Sent: 25 May 2012 14:14
To: Planning
Subject: Welwyn Hatfield Council Online Planning - Comment

Application Number: W6/2012/0766/EM

Address: 179 Parkway, Welwyn Garden City AL8 6JA Comment Type: Object

**Ground Floor Proposed**  
1 : 50

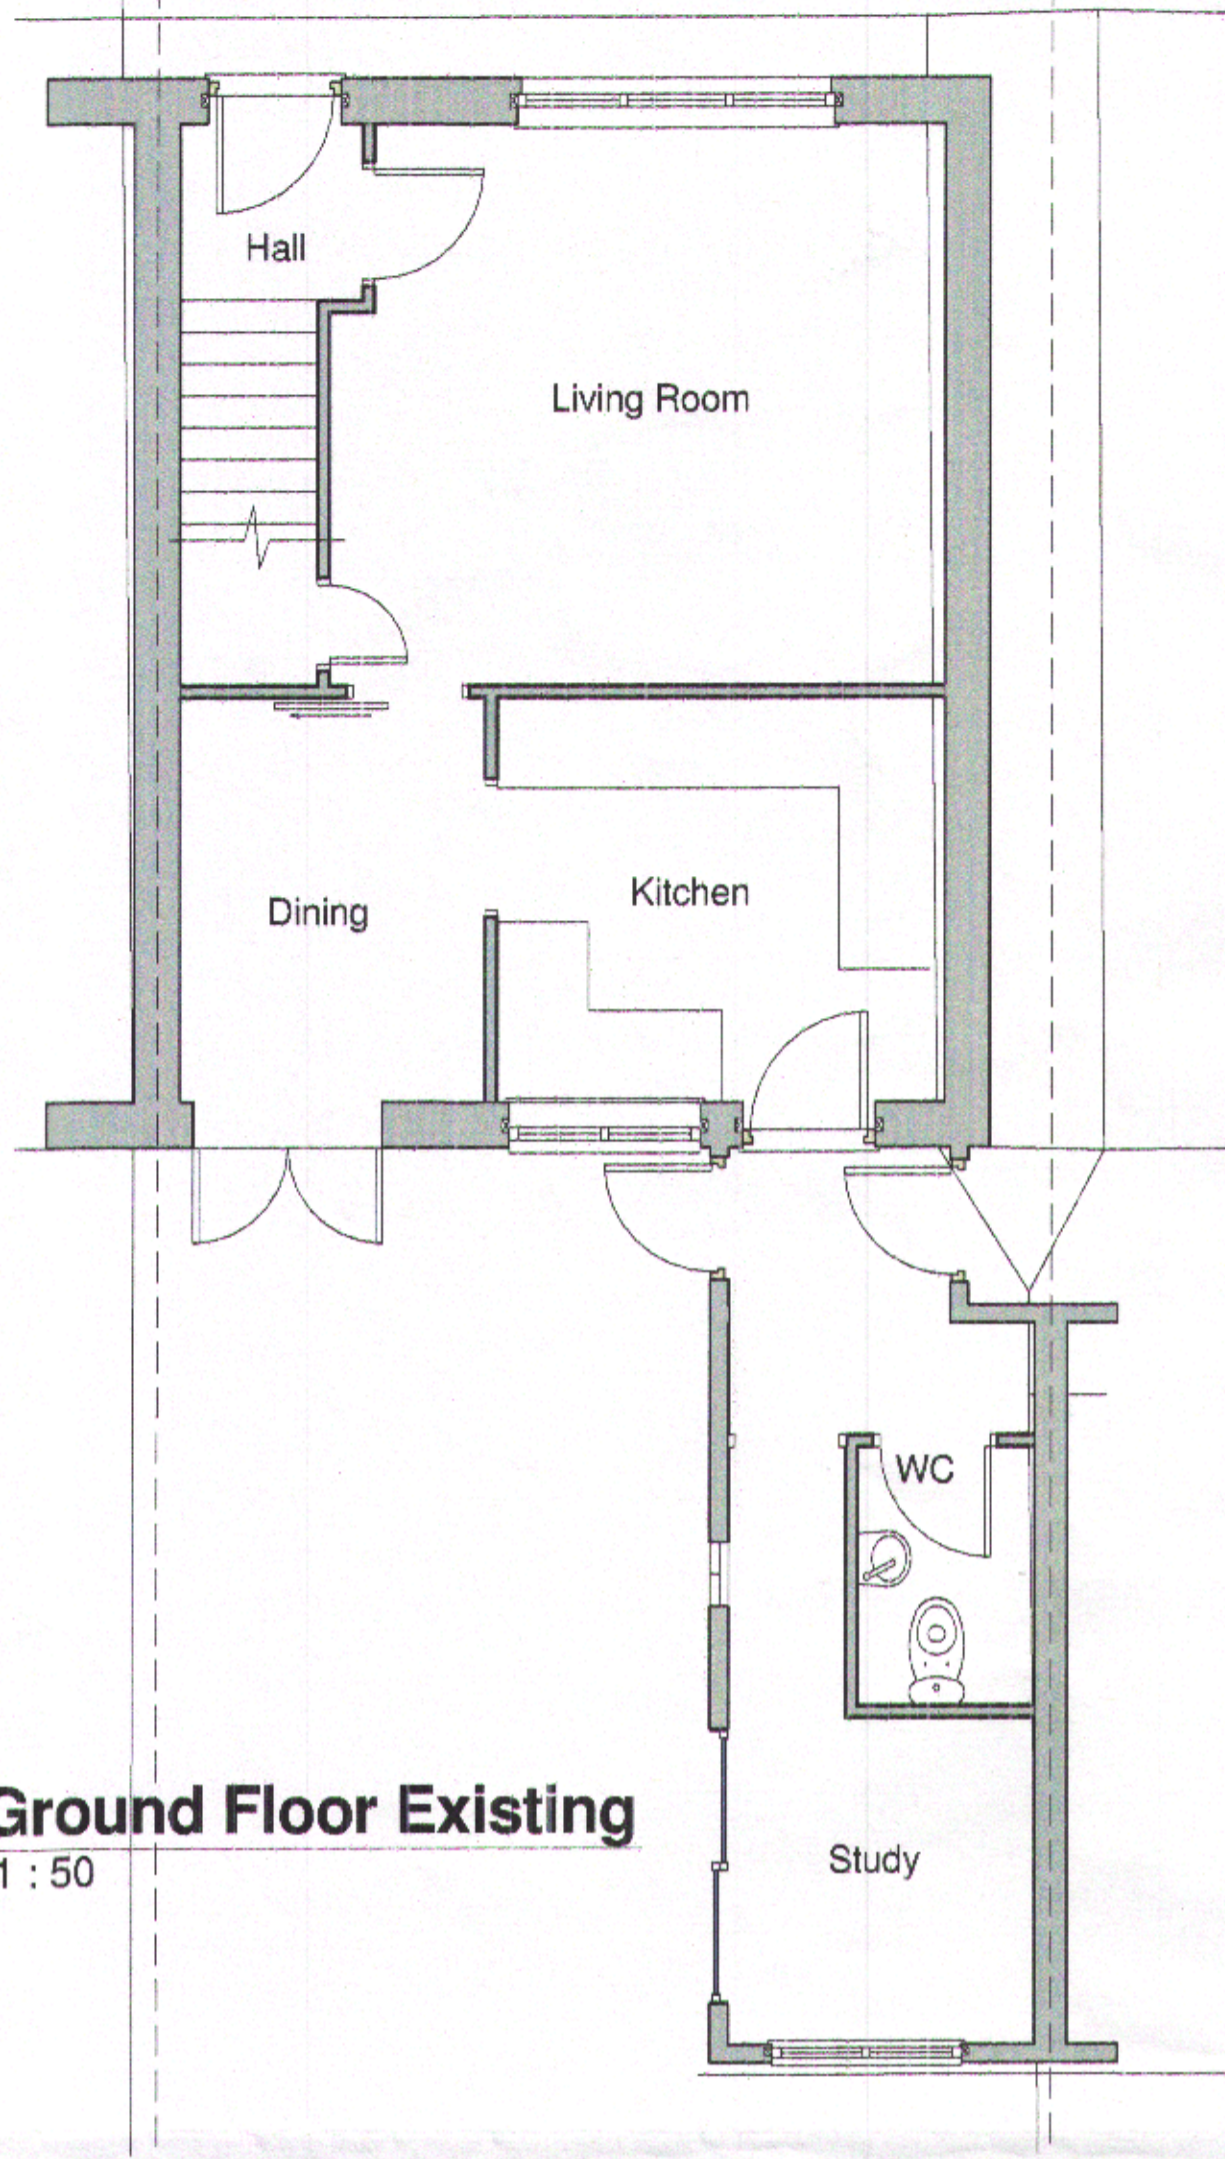
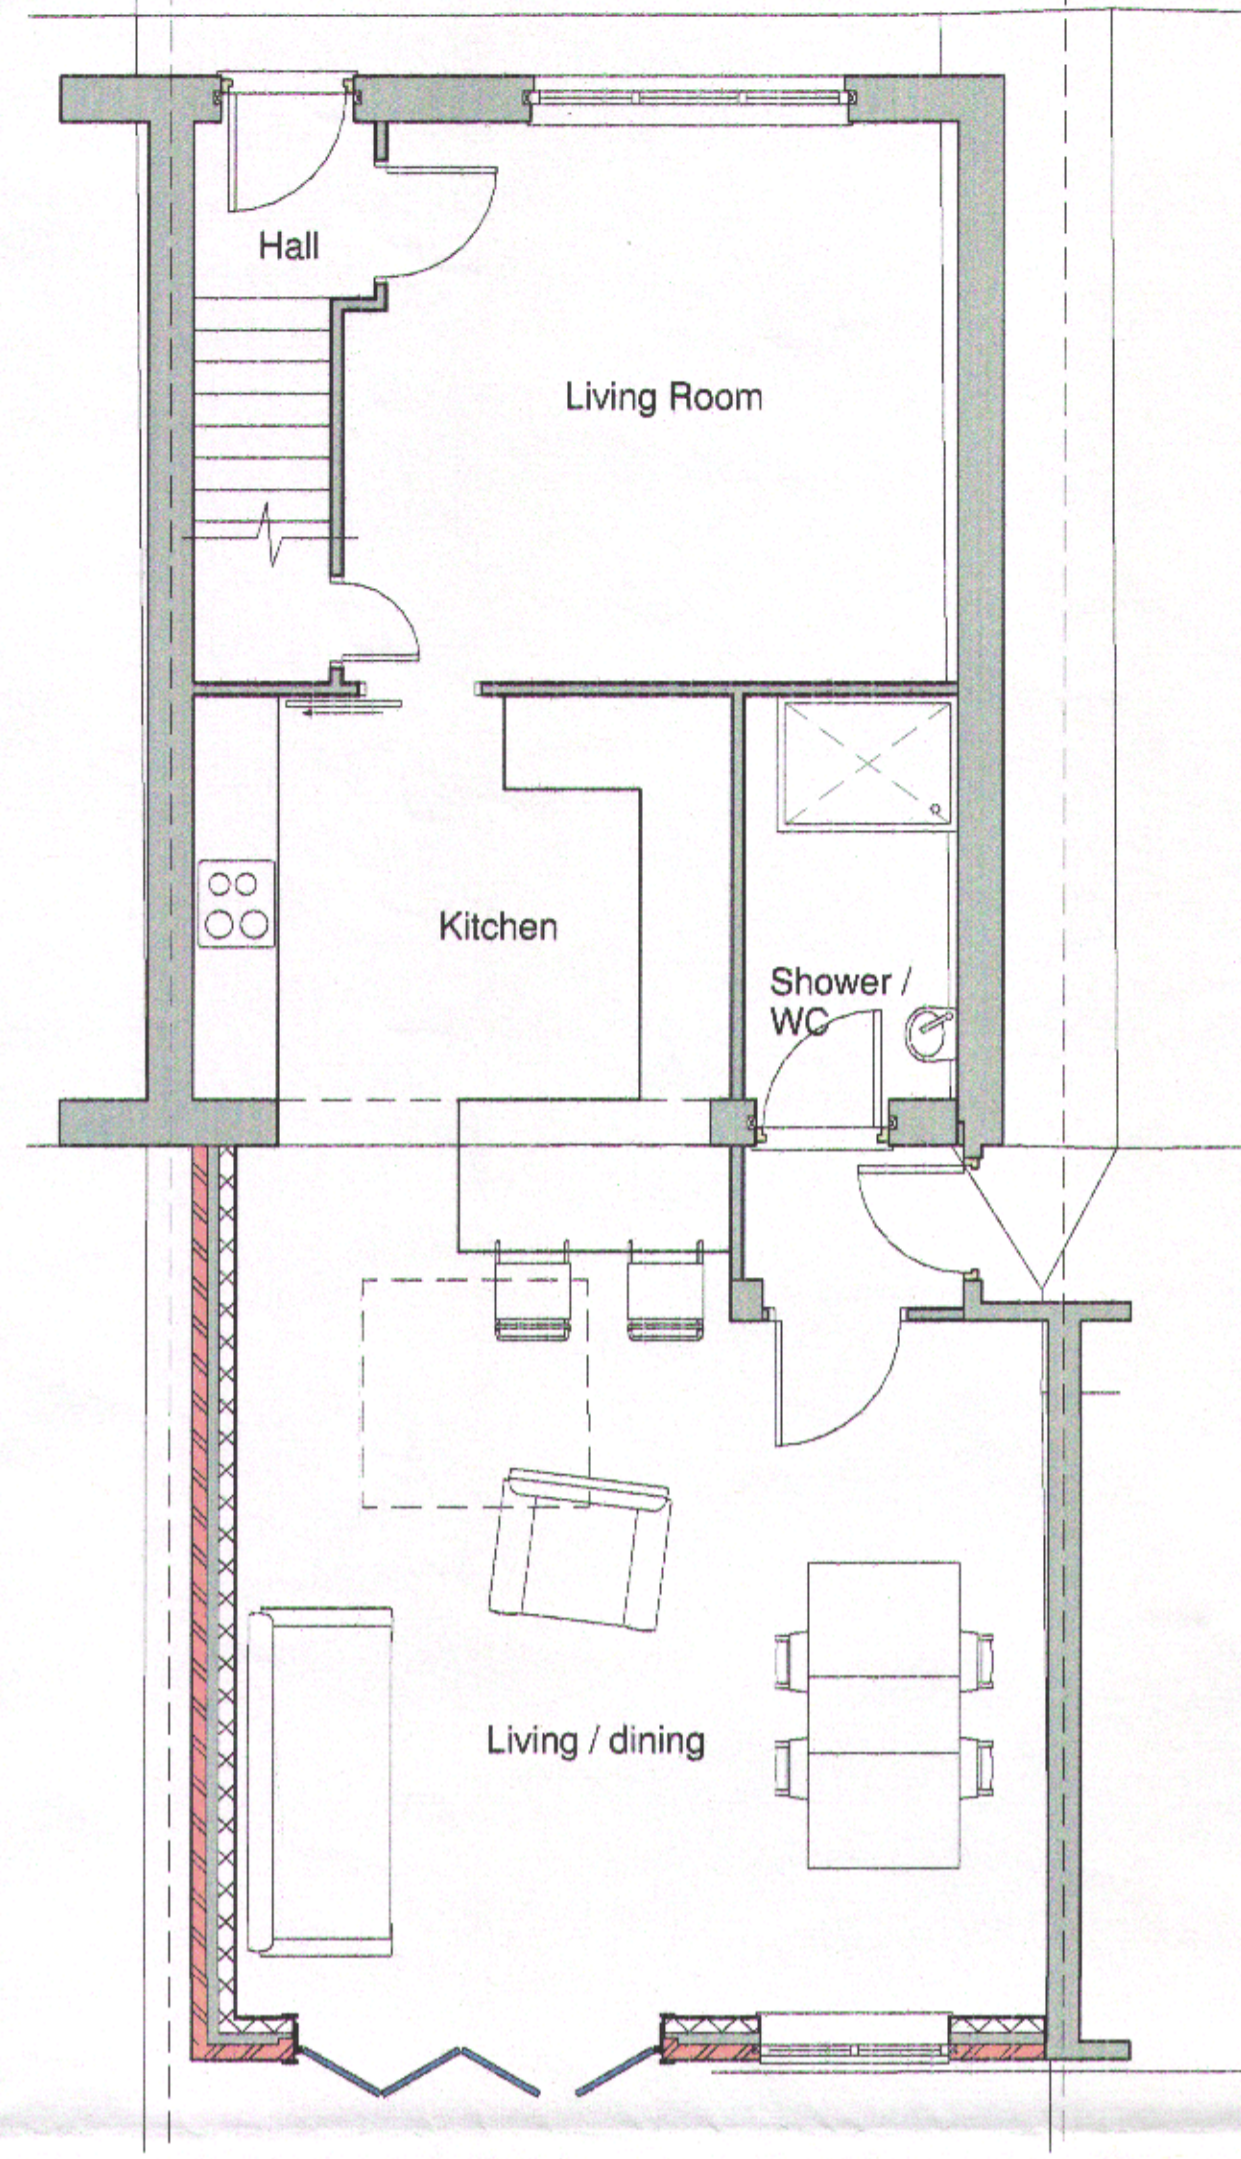
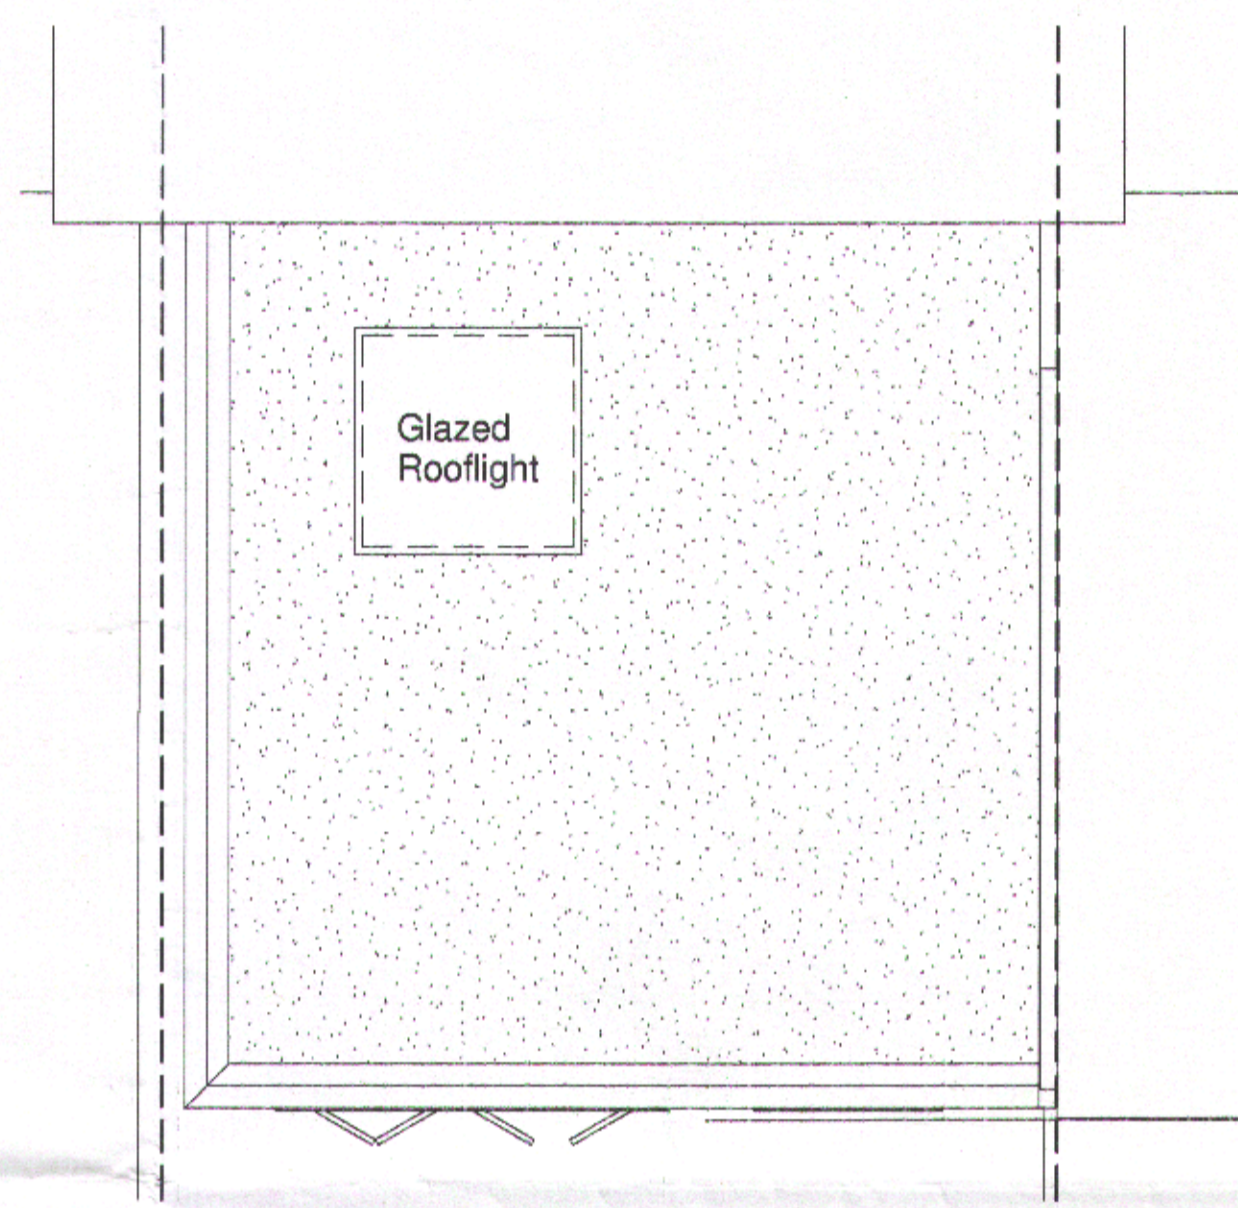
Comment: I consider that the proposed plans for the above extension will have a negative effect on myself, my property and gardens. I consider the current planning dimensions are out of character for this area. I therefore object to the current proposal. I suggest that the planned extension is reduced in length enabling it to remain in line with neighbouring one storey extensions, and that it is reduced in height in order to minimize the overbearing appearance from my property, which will ultimately reduce daylight into my own extension. It is highly important to acknowledge that any proposed extension of this size would need to be at least one metre from the neighbouring boundary in order to {1}Allow some additional light to my property and {2} to provide suitable space for the builder to carry out the proposed work as it would be impossible for work to be done that would impinge on my side of the boundary.
